From: Andrew Wood <Andrew.Wood@arun.gov.uk>
Sent: 21 November 2019 09:29
To: Planning.Responses <Planning.Responses@arun.gov.uk>
Subject: FW: WA/7/19/RES - Lanes End, West Walberton Lane - Additional information request

From: Mark Warwick <Mark.Warwick@arun.gov.uk>
Sent: 23 October 2019 13:02
To: Andrew Wood <Andrew.Wood@arun.gov.uk>
Subject: RE: WA/7/19/RES - Lanes End, West Walberton Lane - Additional information request

WA/7/19/RES - Lanes End, West Walberton Lane - Additional information request

PJ DEVELOPMENTS LTD 2 Square Chambers 23 High Street Emsworth PO10 7AQ Tel: 0843 289 3430 Email: enquiries@pjdevelopmentsltd.com	
PROJECT: FORMER LANES END	
SITE PLAN OUTLINE PLANNING APPLICATION	
DATE: JANUARY 2019	DWG. NO 19-001 PL02
SCALE @ A1: 1:200	
REV: C

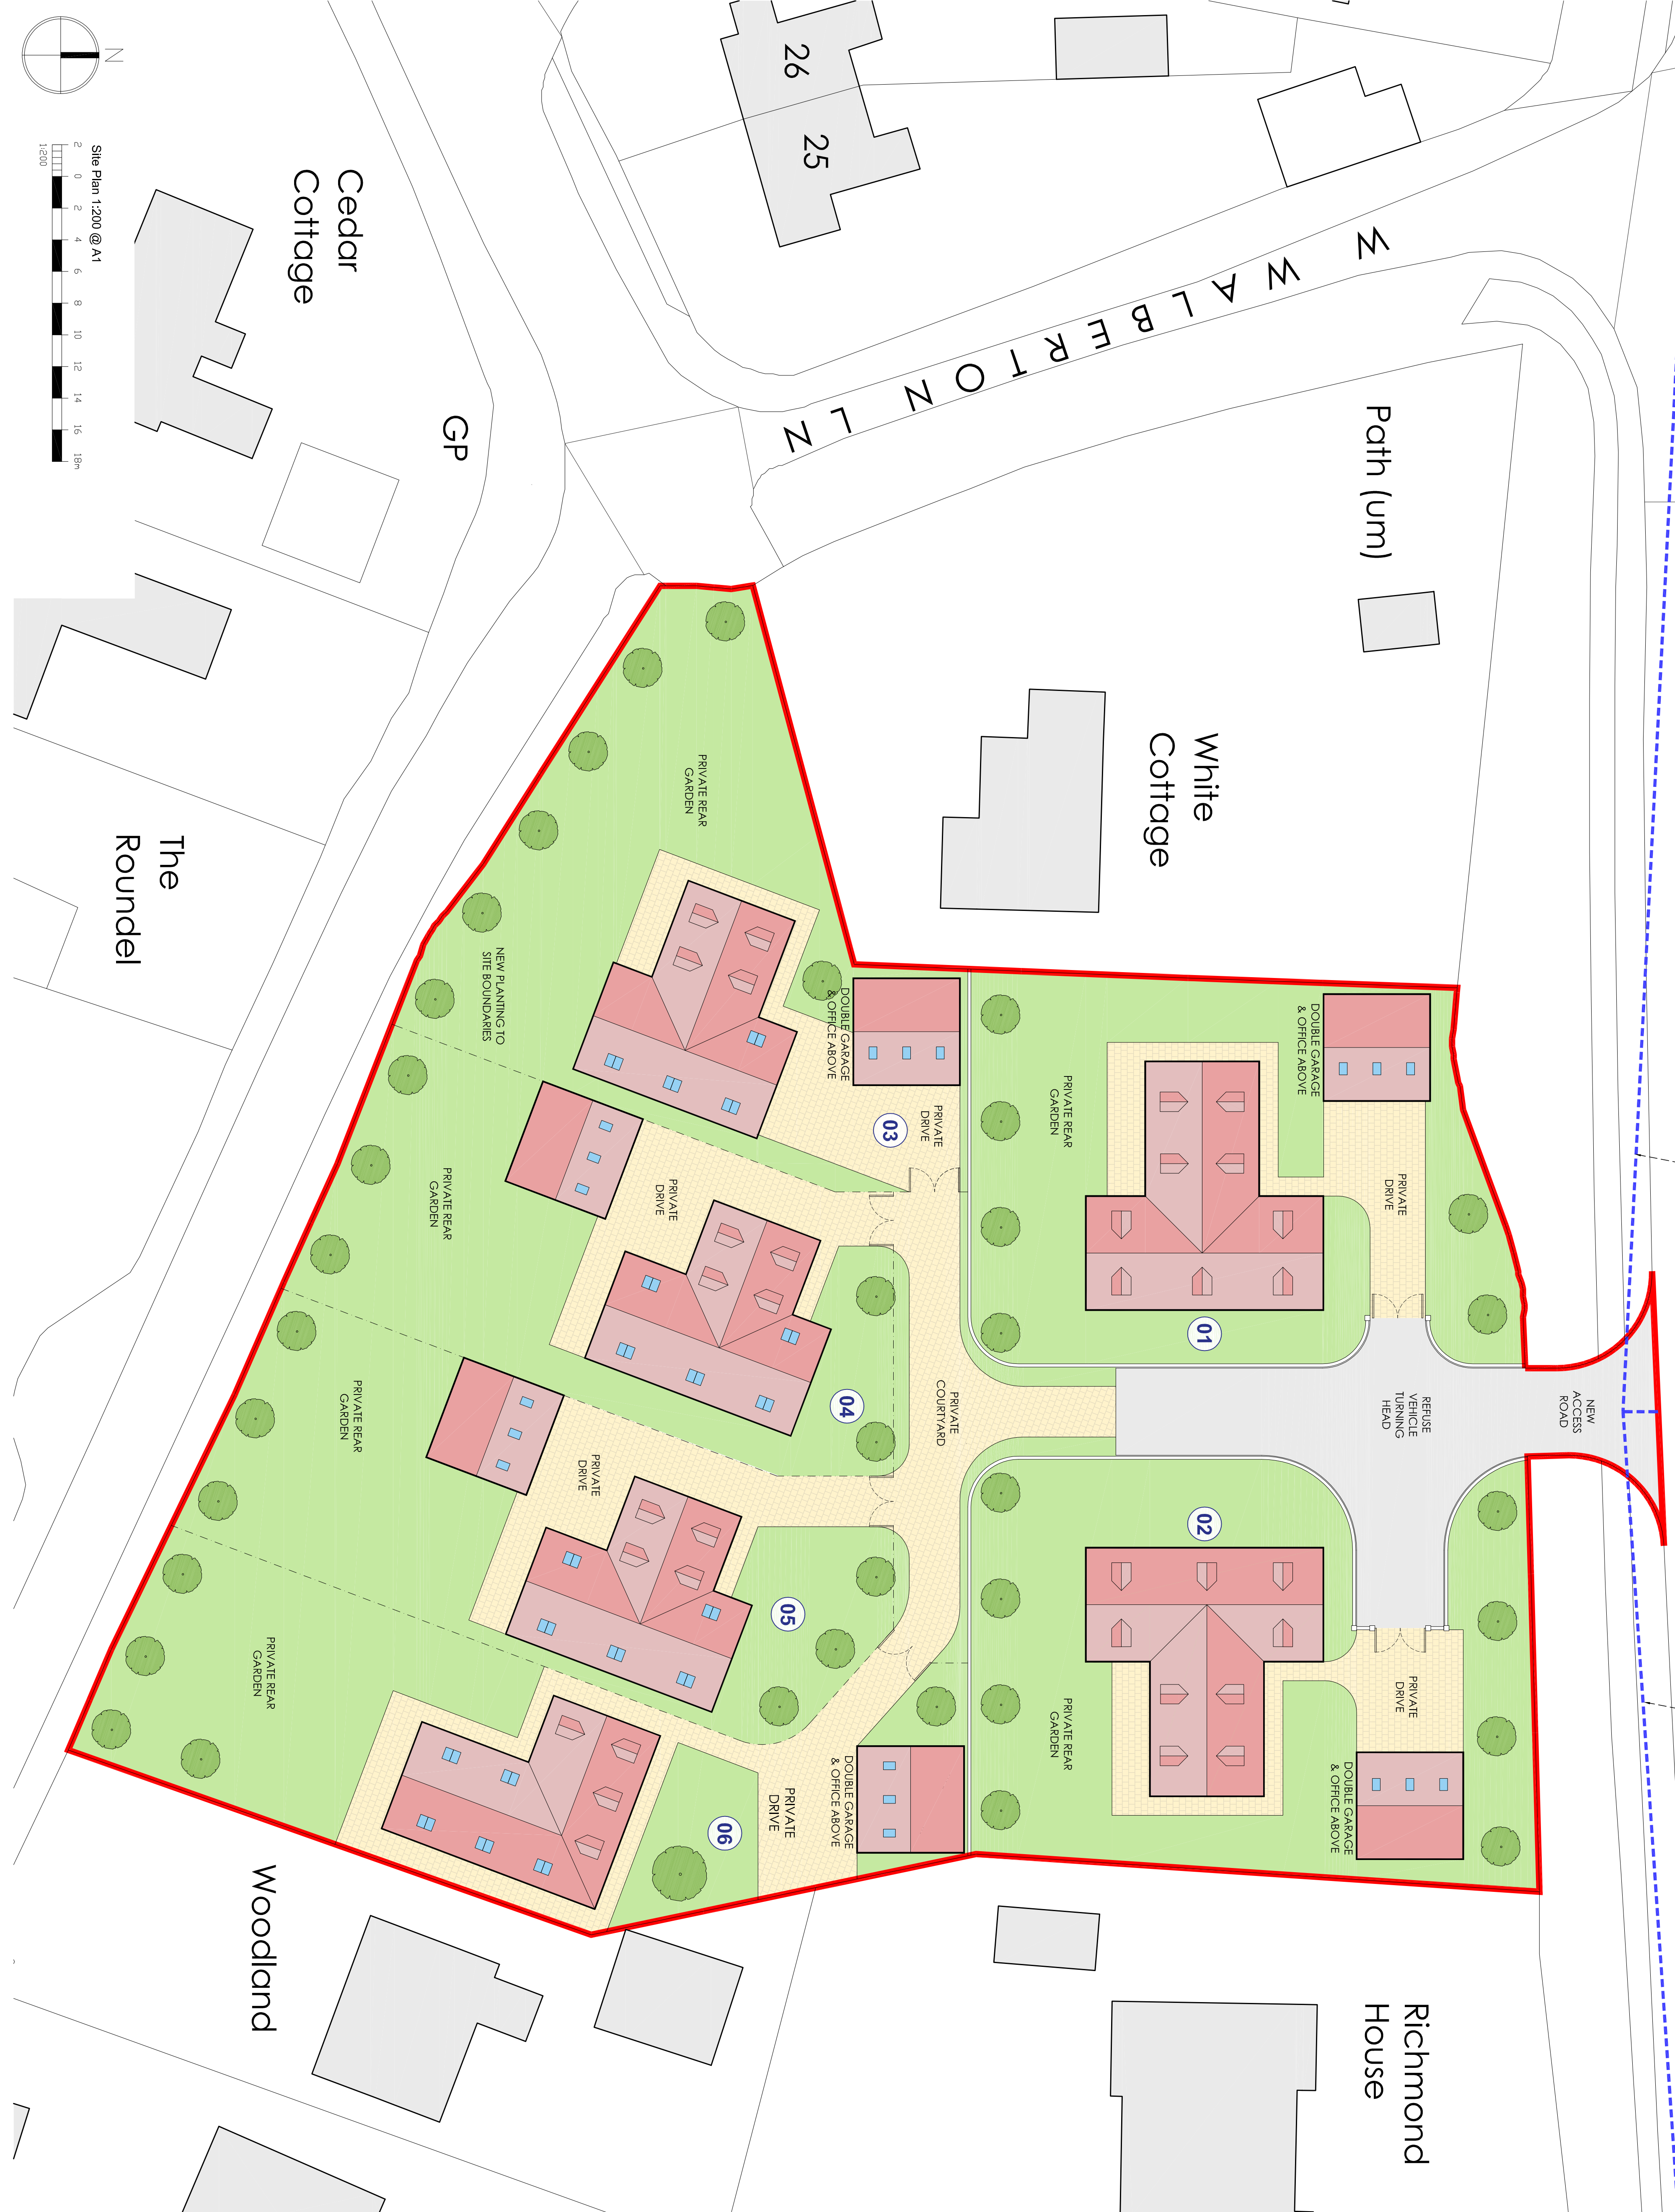
1. Amend the layout to ensure that a minimum of 9 metres exists on from blank gable end (or obscure glazed windows non opening below 1.7 metres in height) of nearest proposed house to gable end of 'Woodlands' which currently incorporates sole habitable room windows.
2. Remove second storey of houses/rooms in roof. 3 storey townhouses would not be acceptable in this location

1, Happy to amend property six to make a nine metre distance.
